SUBJECT: Engineering Review Comment
Mountain View Electric Association Inc. (MVEA)

Project Name: Canyon Creek Ranch

Project Number: SF2440

Description: Proposed development of 3 residential lots and 2 tracts located at 11550 Parallax Hts. in Township 12S, Range 66W, Section 12.

CANYON CREEK RANCH  
JOB NO. 25322.00  
JULY 13, 2026  
SHEET 2 OF 4

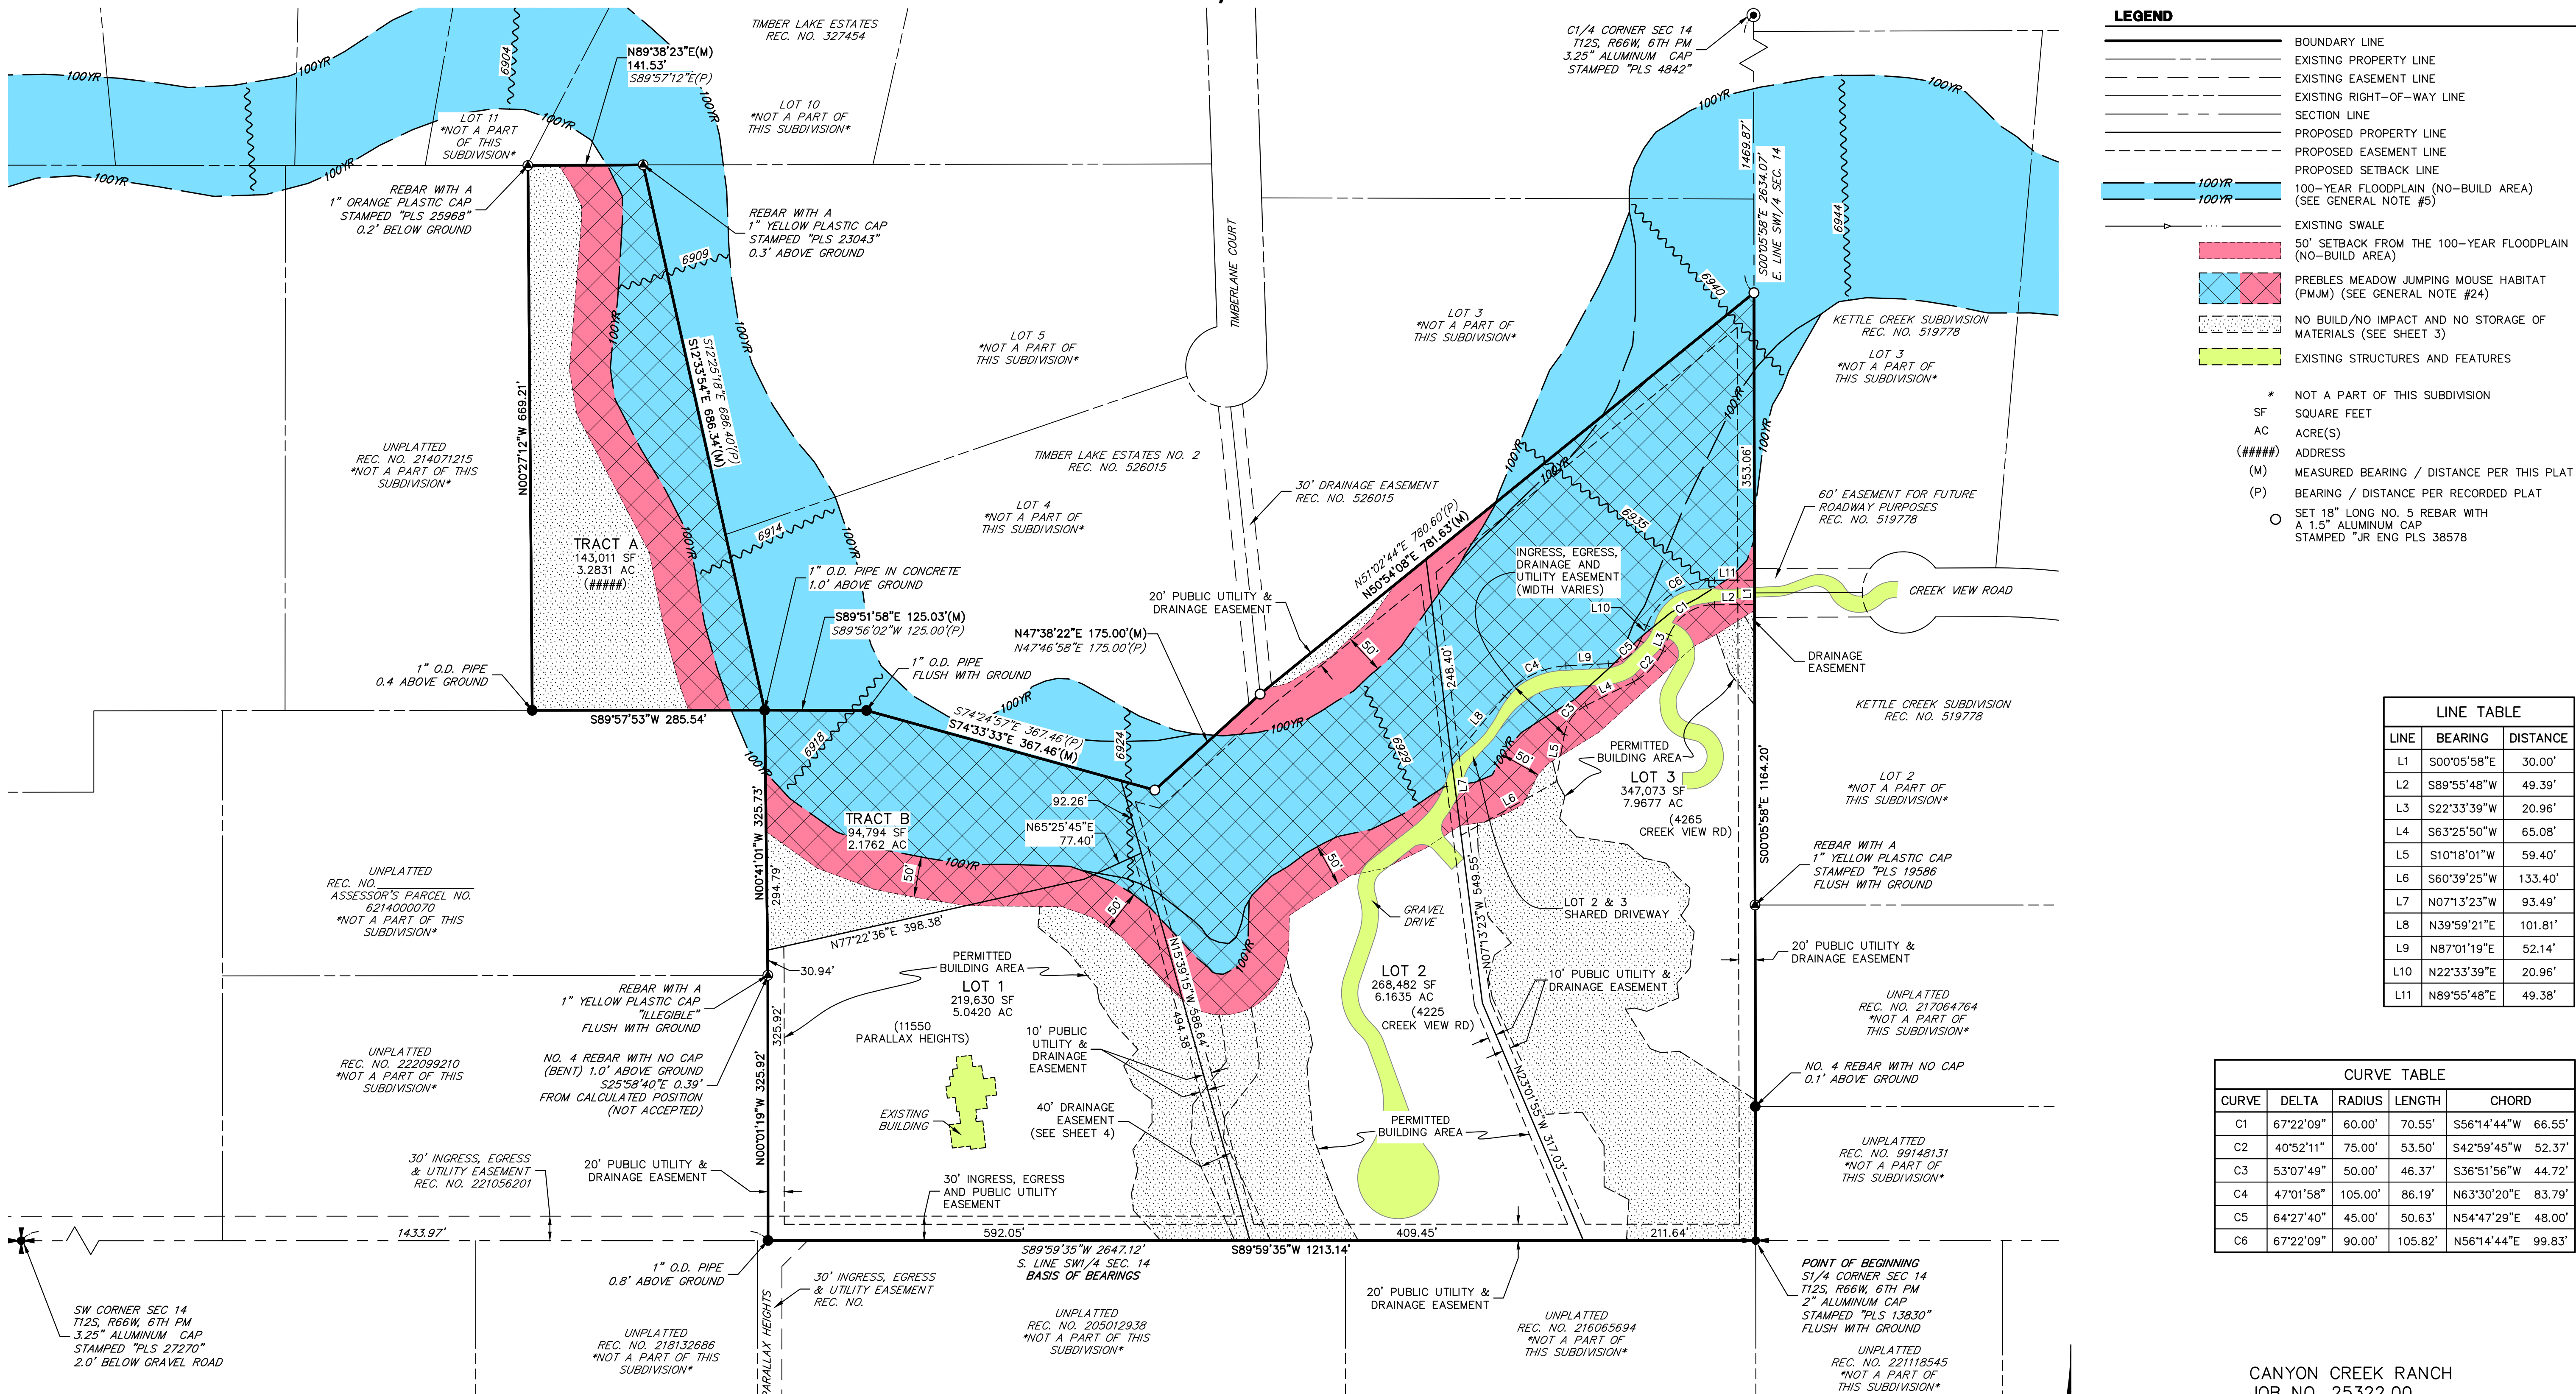
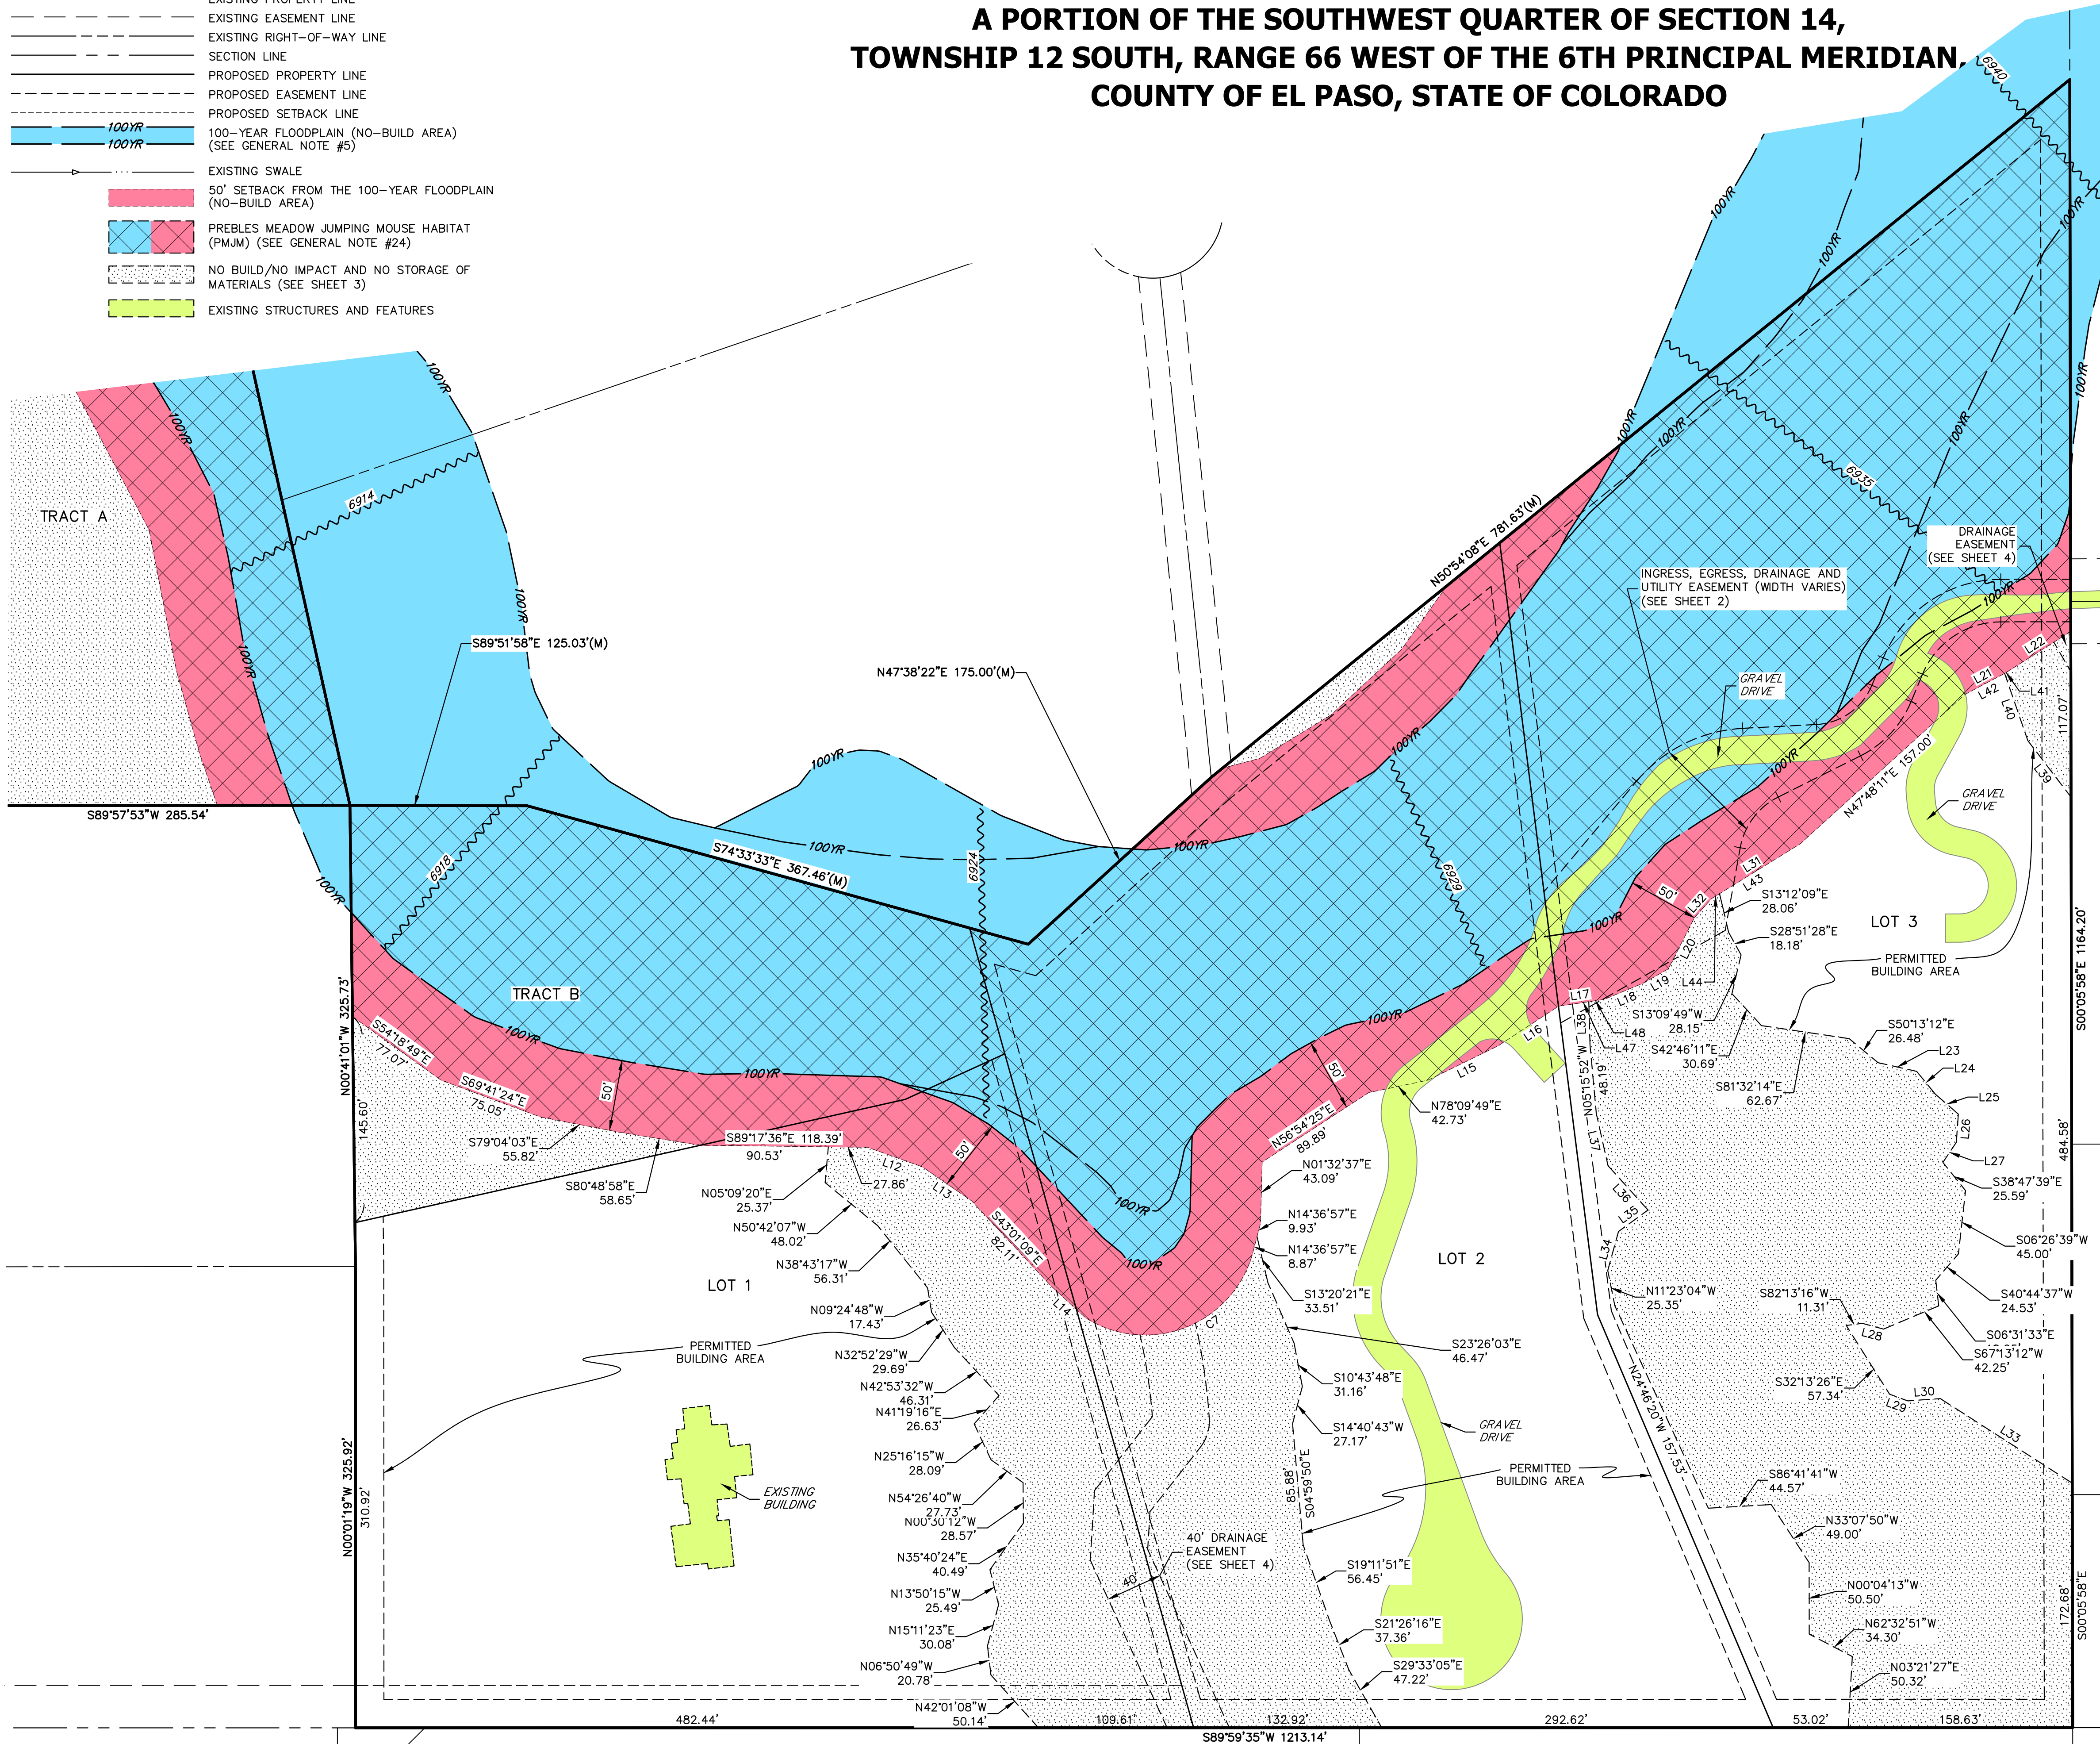
MVEA requests a ten (10) foot front, side, and rear lot utility easement and all tracts, along with a twenty (20) foot exterior utility easement on the plat. MVEA also requests the platting of MVEA's existing facilities with easements on the plat. Additional easements may be required.
